**WEST SUSSEX COUNTY COUNCIL
STRATEGIC PLANNING CONSULTATION**

SUBJECT: AW/215/14/A - 3No. internally illuminated fascia signs to front and west side elevations, 1No. externally illuminated fascia sign to east side elevation and 2No. externally illuminated projecting signs to front and east side elevations.

Ship Inn, Aldwick Street, Aldwick, West Sussex, PO21 3AP

Bus Stop Sign shown at 1:20 scale @ A3

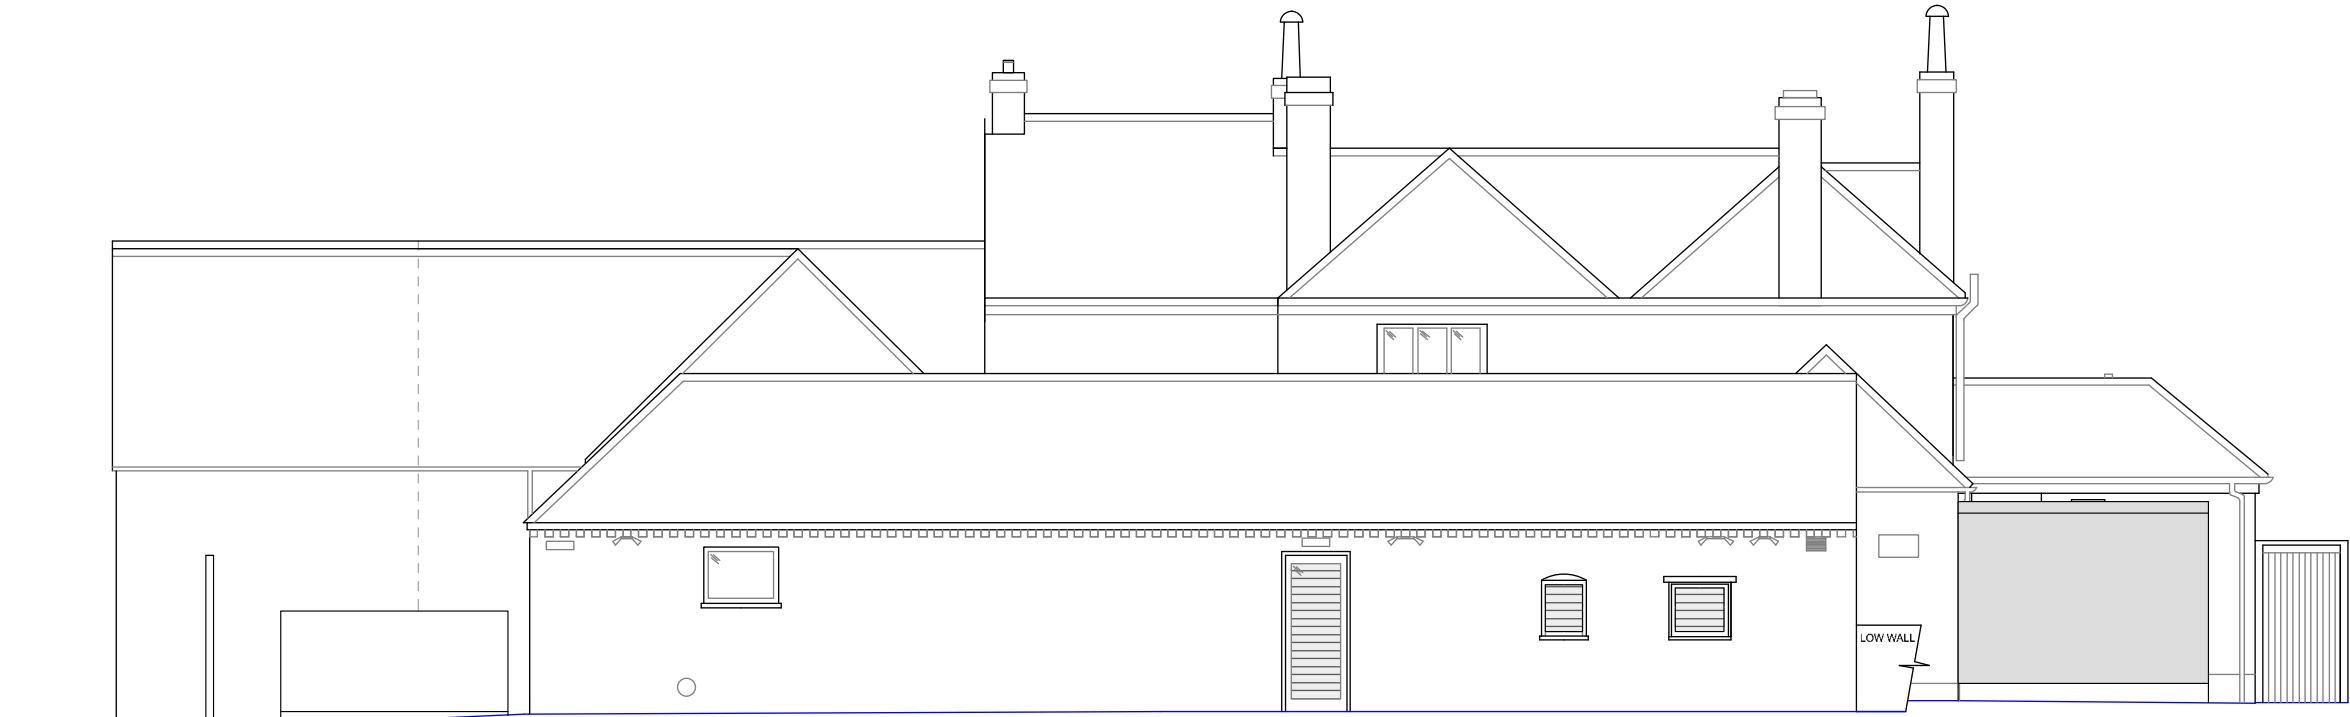
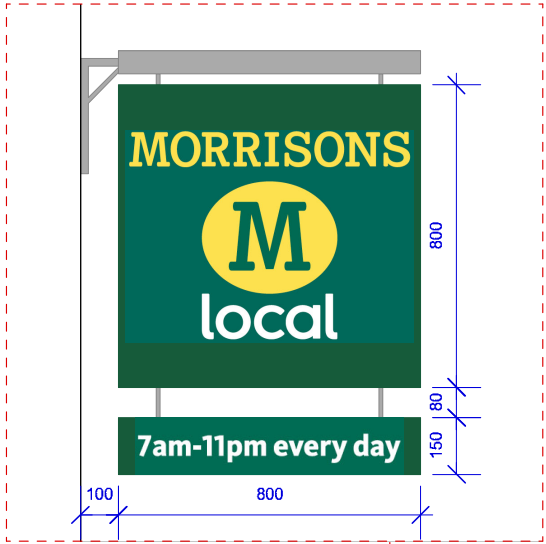
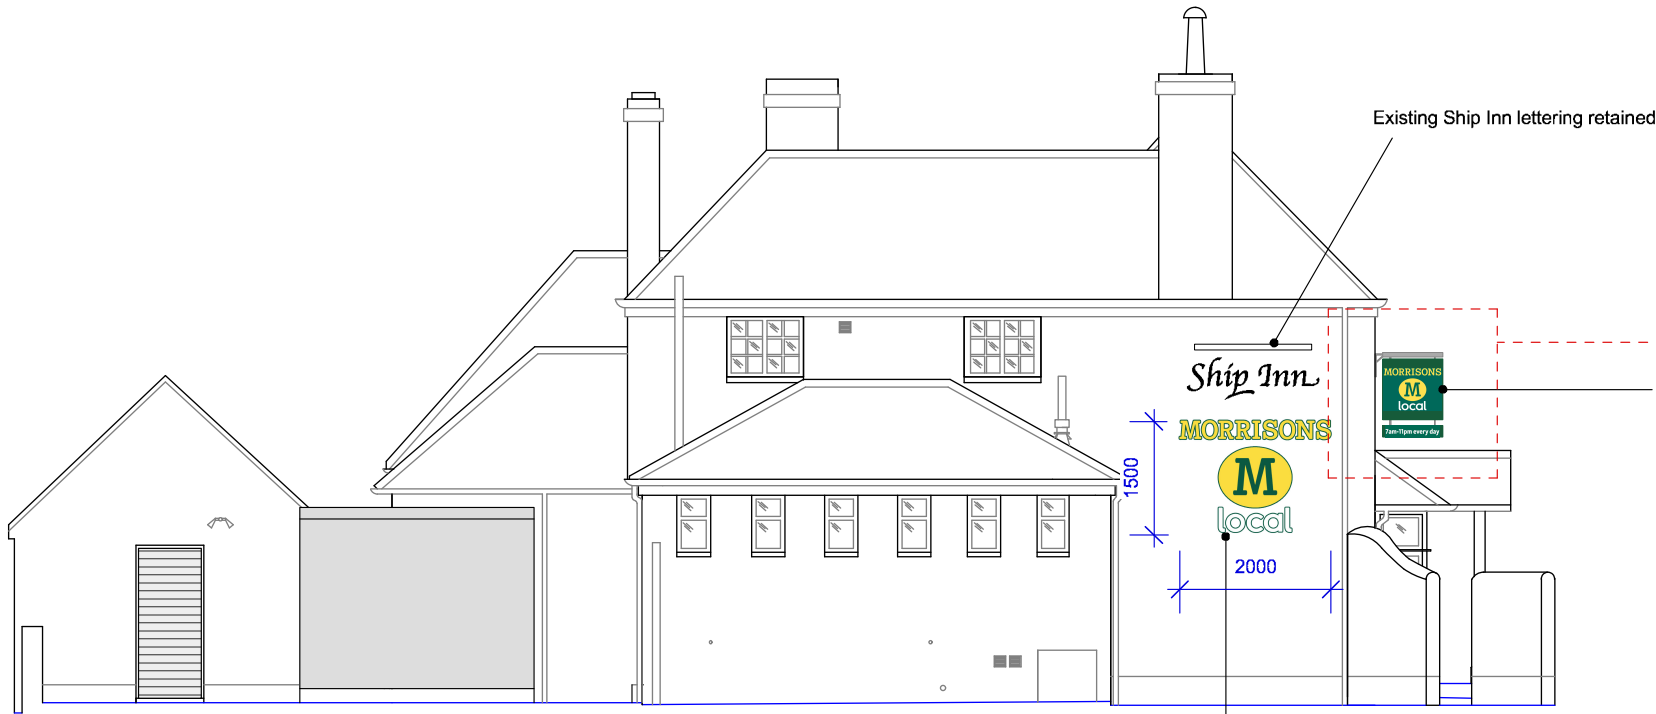
The proposed signage has a proposed luminance level of 250 cd/m². This is below the recommendations made by the Institute of Lighting Engineers for illuminated signs in a location such as Aldwick.

The proposed projecting sign will project over land considered to be publically maintained highway. A Section 177 Licence will therefore be required.

Before the commencement of any operation, the applicant is advised to contact West Sussex County Council (Tel no: 01243 642105 or email street.works@westsussex.gov.uk) to obtain a Section 177 Licence under the Highways Act 1980 to cover any structure that overhangs the highway.
